This TIS supports the Sterling Ranch East - Phase 1 Preliminary Plan (SP224)

Sterling Ranch East - Phase 1
Rezoning & Preliminary Plan
Traffic Impact Study
(LSC #S224510)

November 17, 2022

SP-22-004, P-22-012, P-22-013

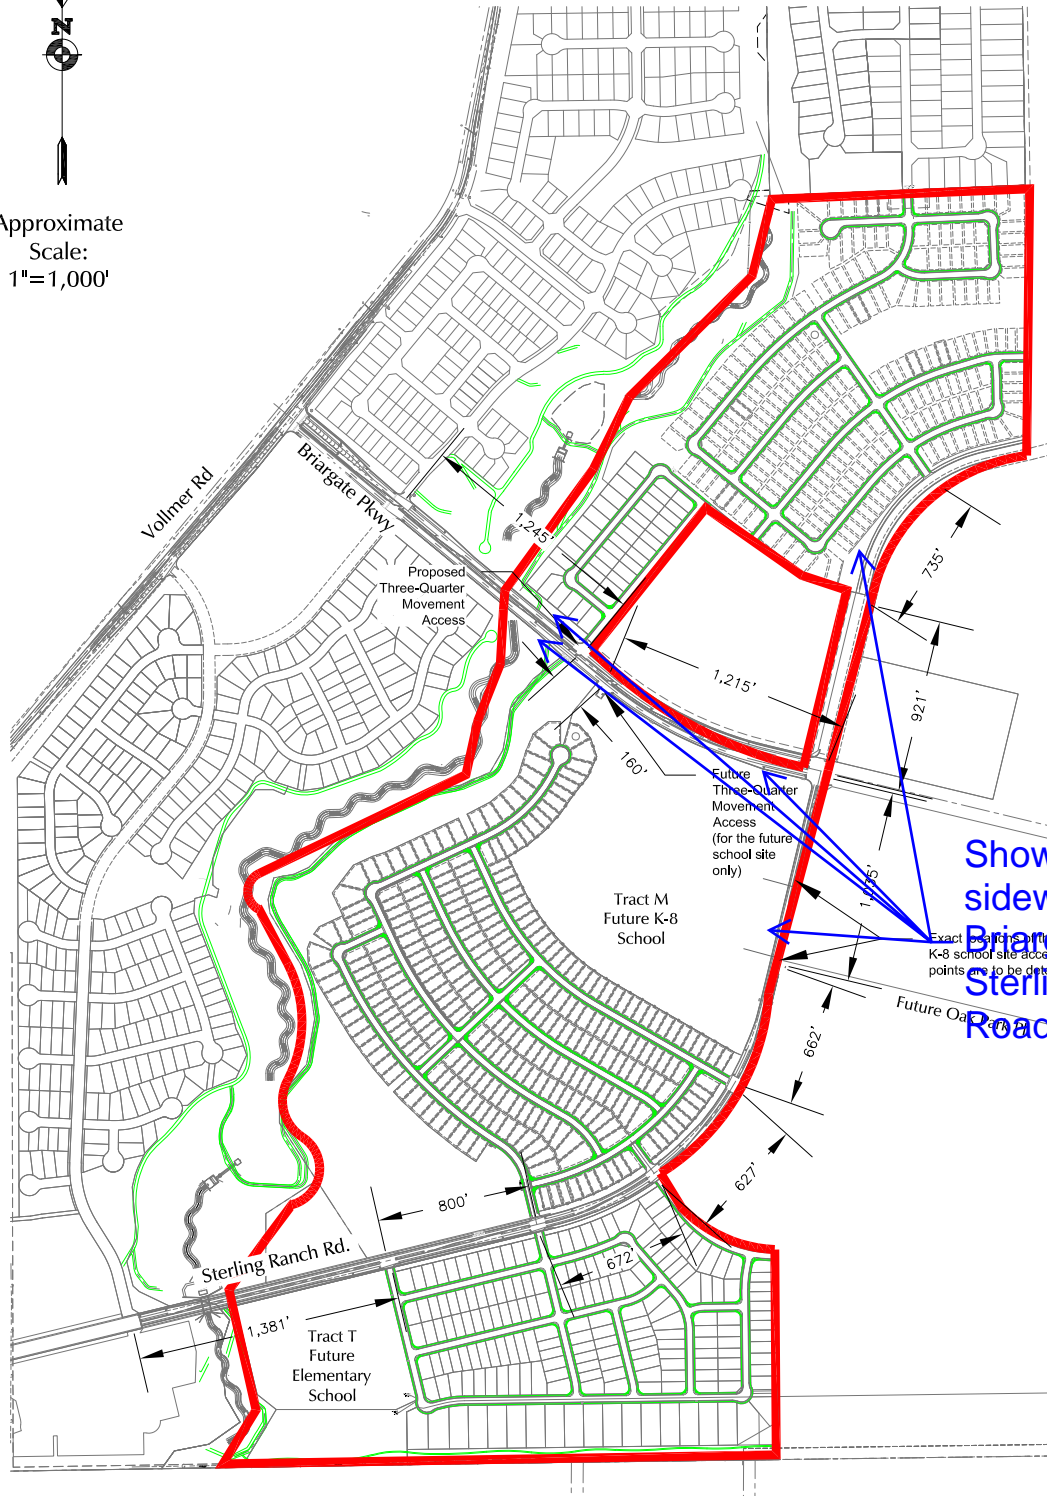
Intersection # 307 (Tract M entrance) is not discussed

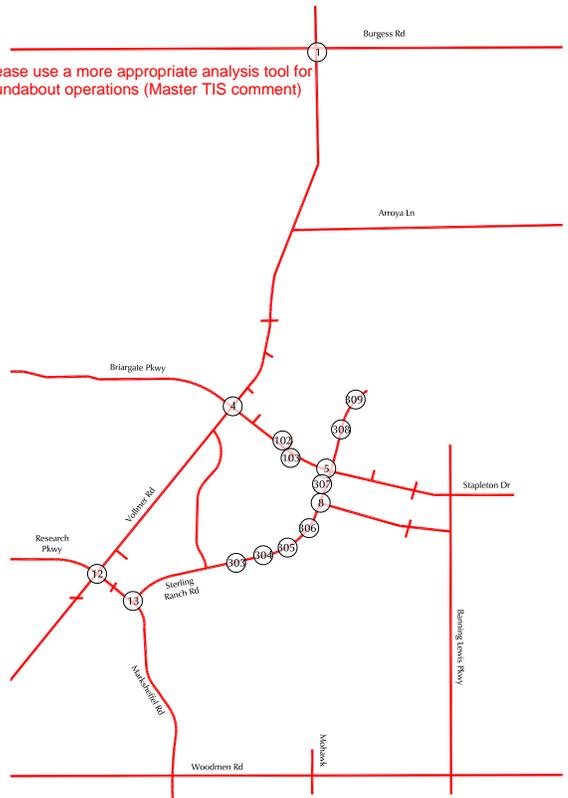
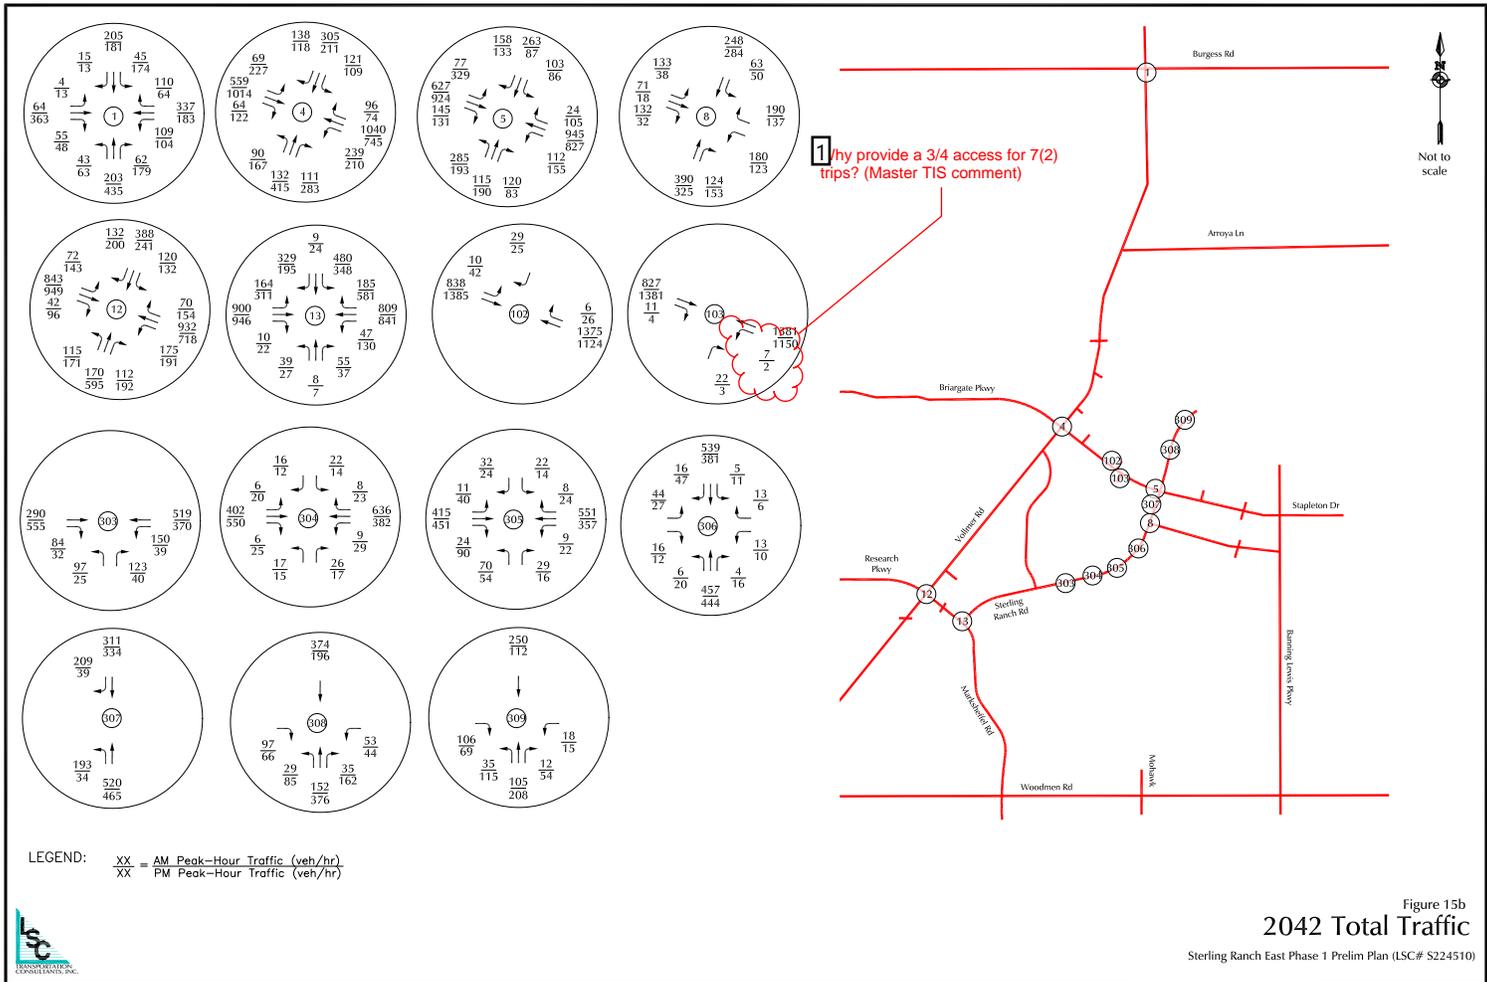
Please use a more appropriate analysis tool for roundabout operations (Master TIS comment)
